Mandy Richardson
Clerk and RFO
Barrow Parish Council
14 Black Lane Croft
Clitheroe
BB7 2EZ

Barrow Parish Council Response – Planning Applicatino 3/2021/0397 Land at Barrow Brook Enterprise Park Barrow BB7 9QZ

Proposed Floor Plan & Elevations

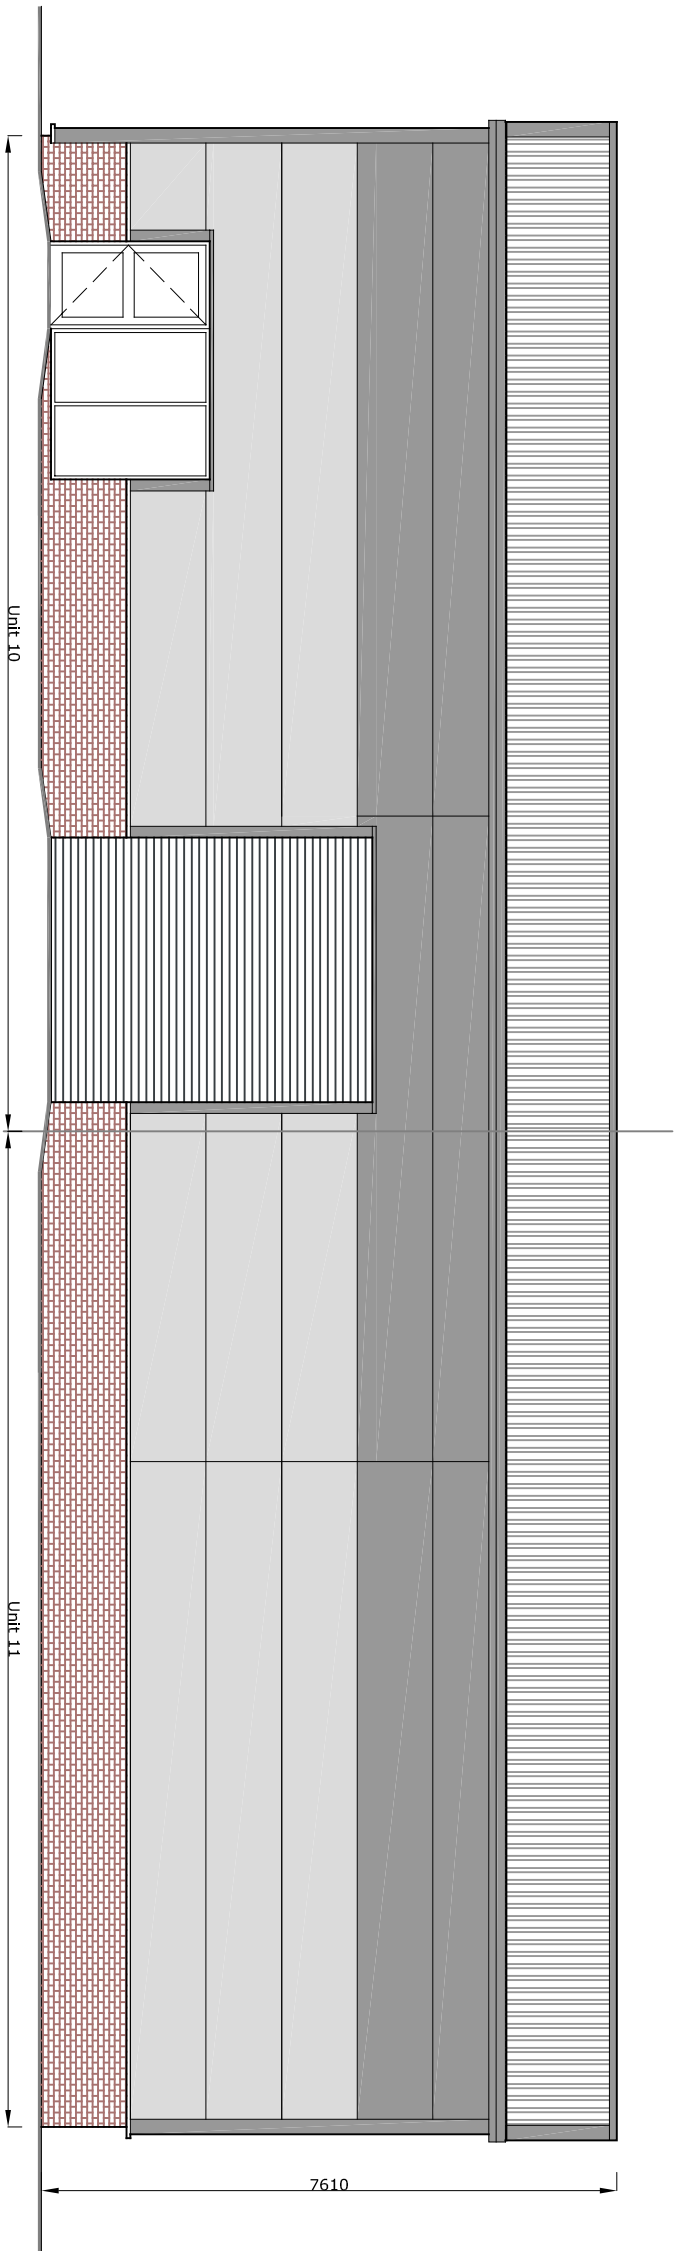
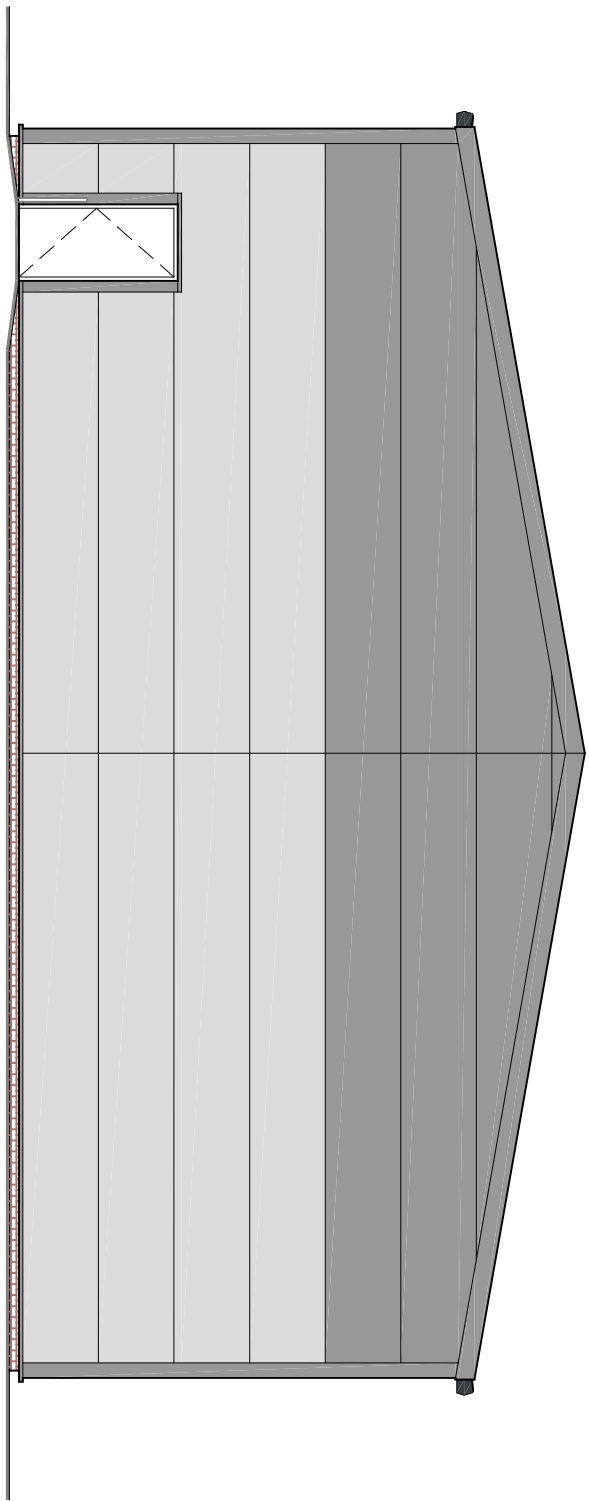
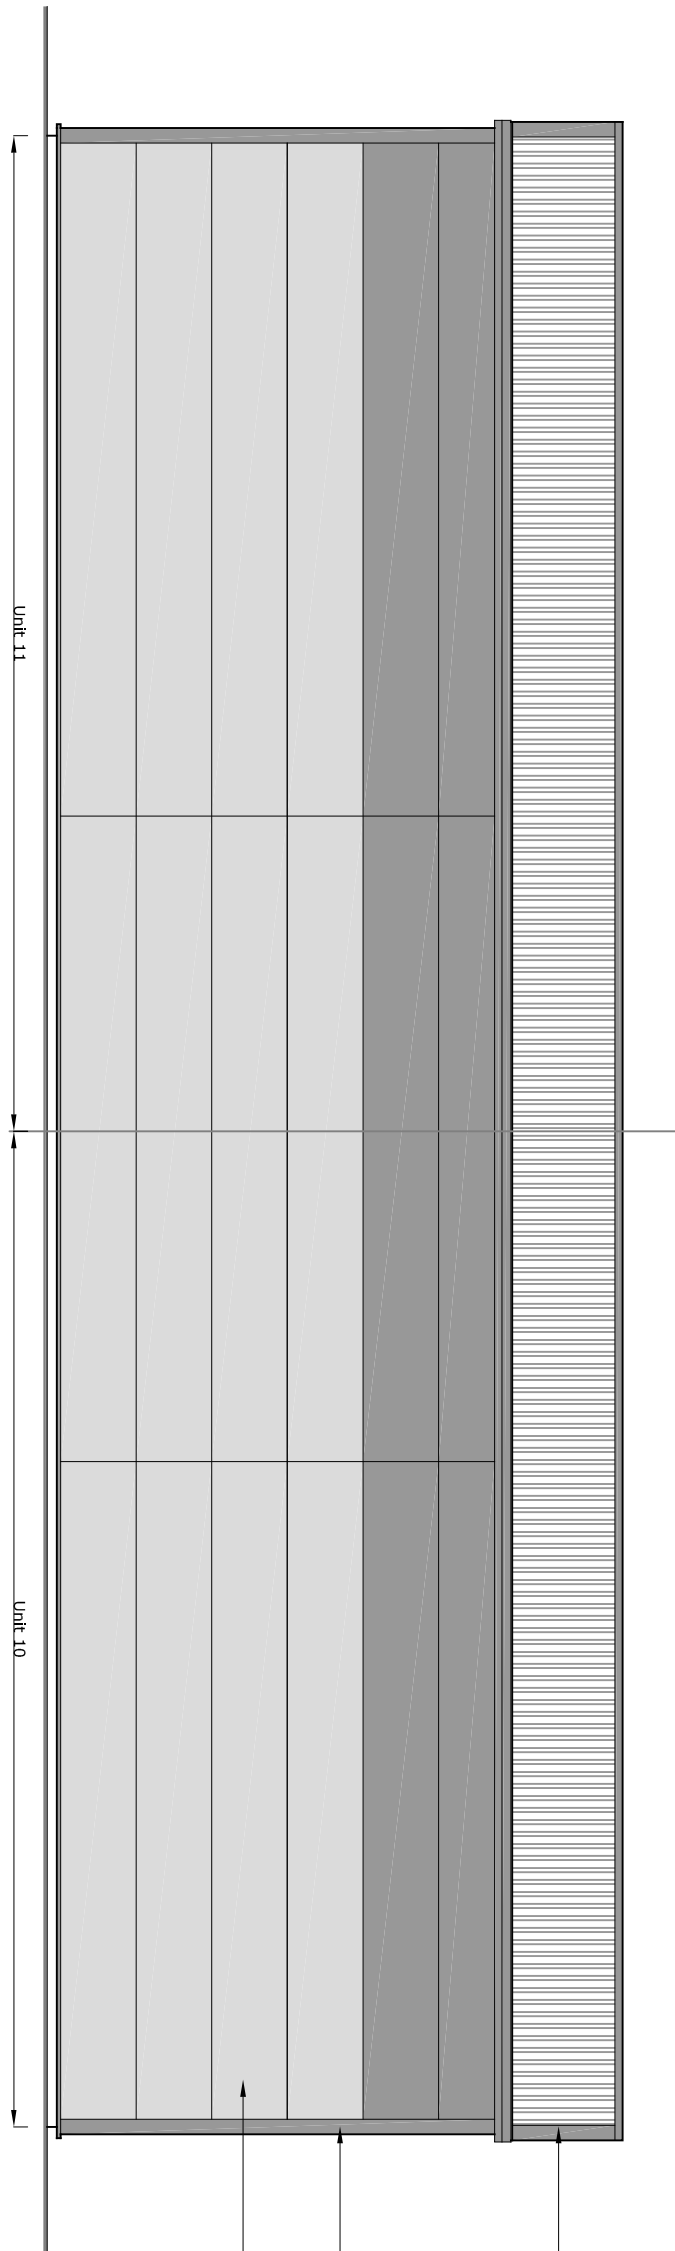
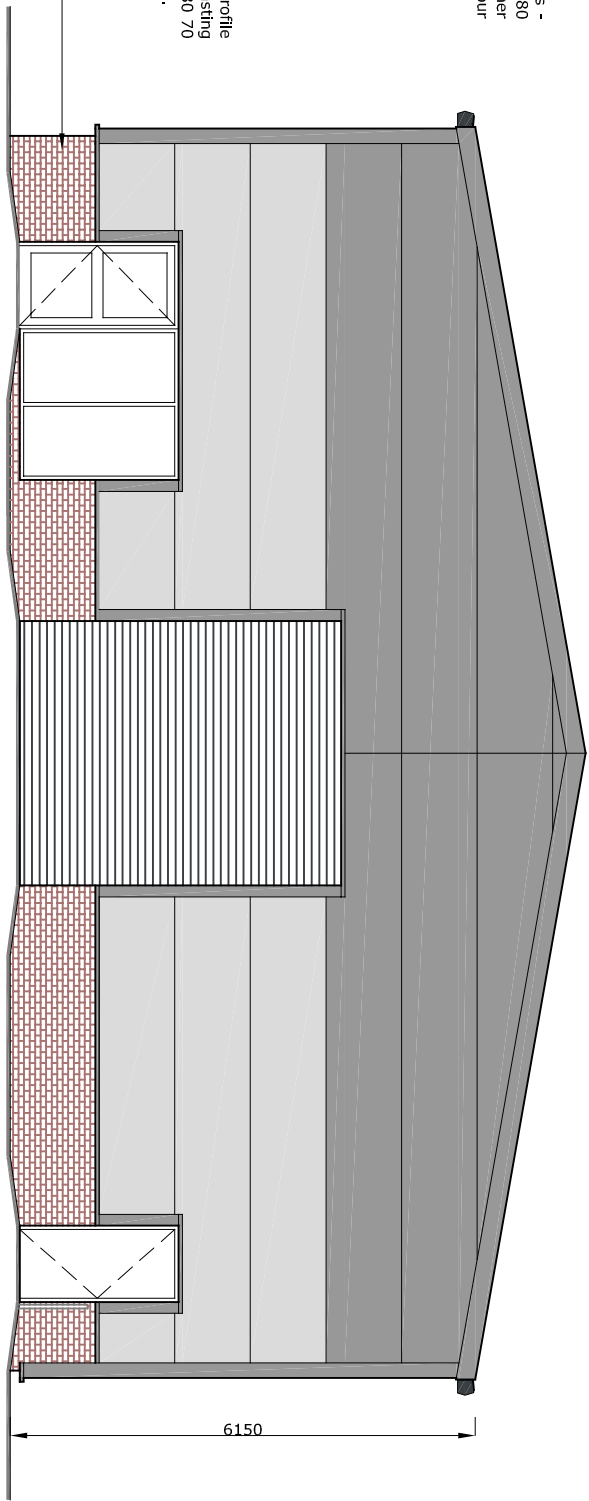
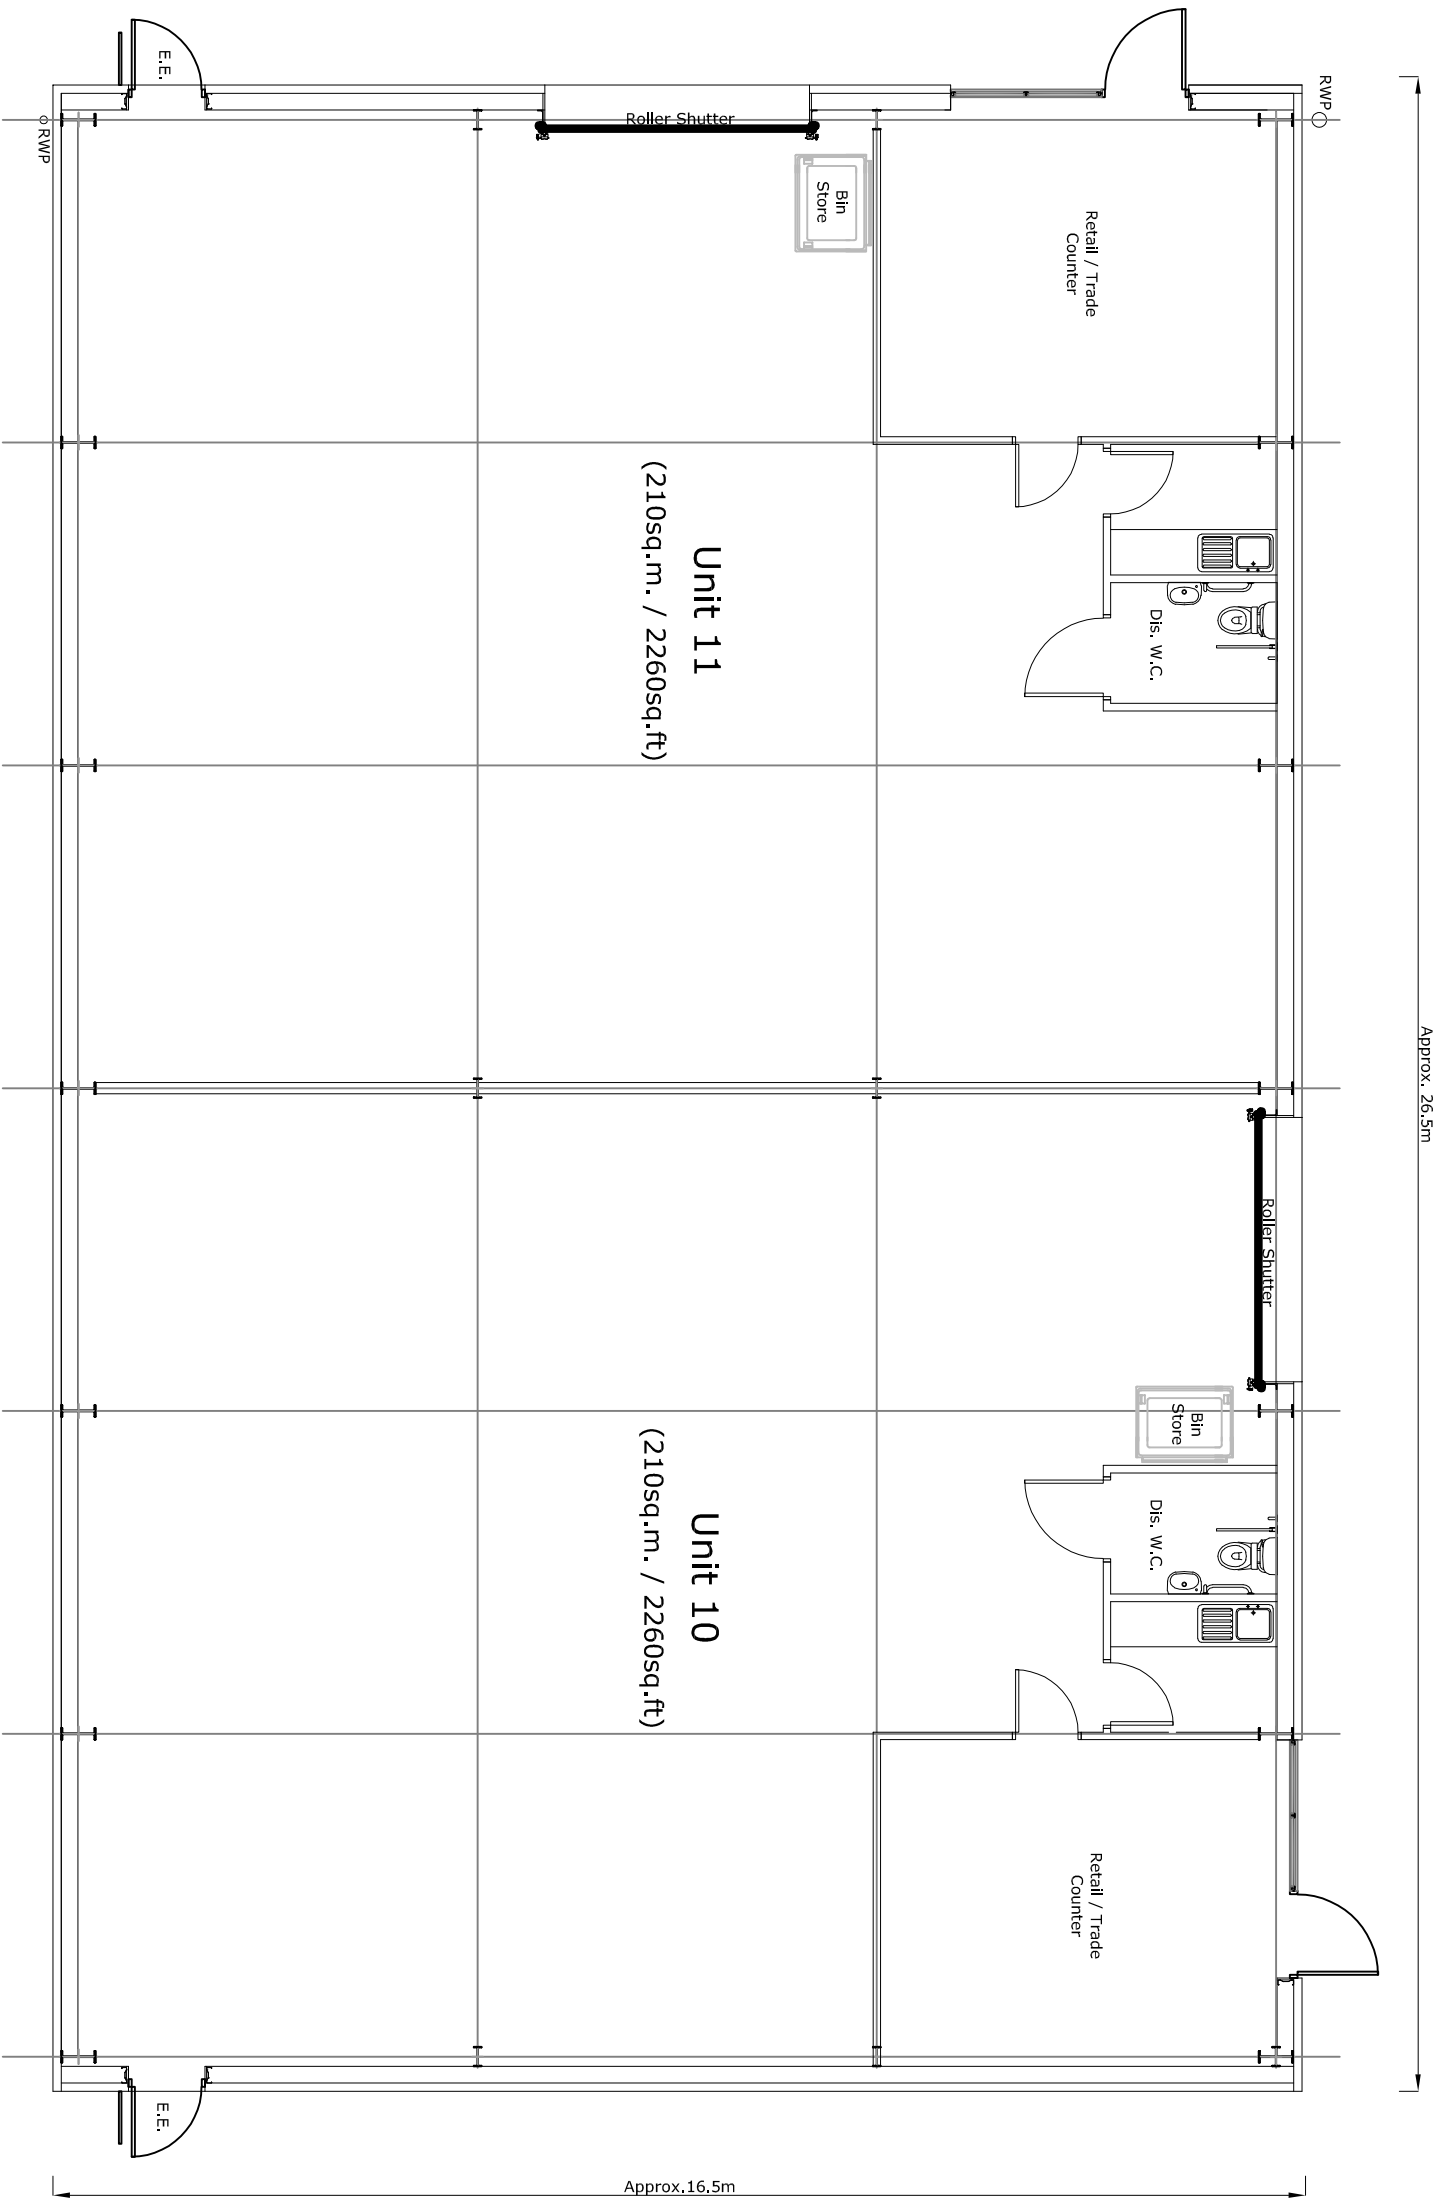
The proposed floor plan - unit 11 shows entrance & roller shutter on the side fronting units 7 - 9. Unit 10 shows entrance & roller shutter on the front, fronting units 1 – 6; this does not match information on point the Design and Access Statement.

Unit 11 is shown before unit 10 on the plans, if this a mistake, should the numbers not be in numerical order?
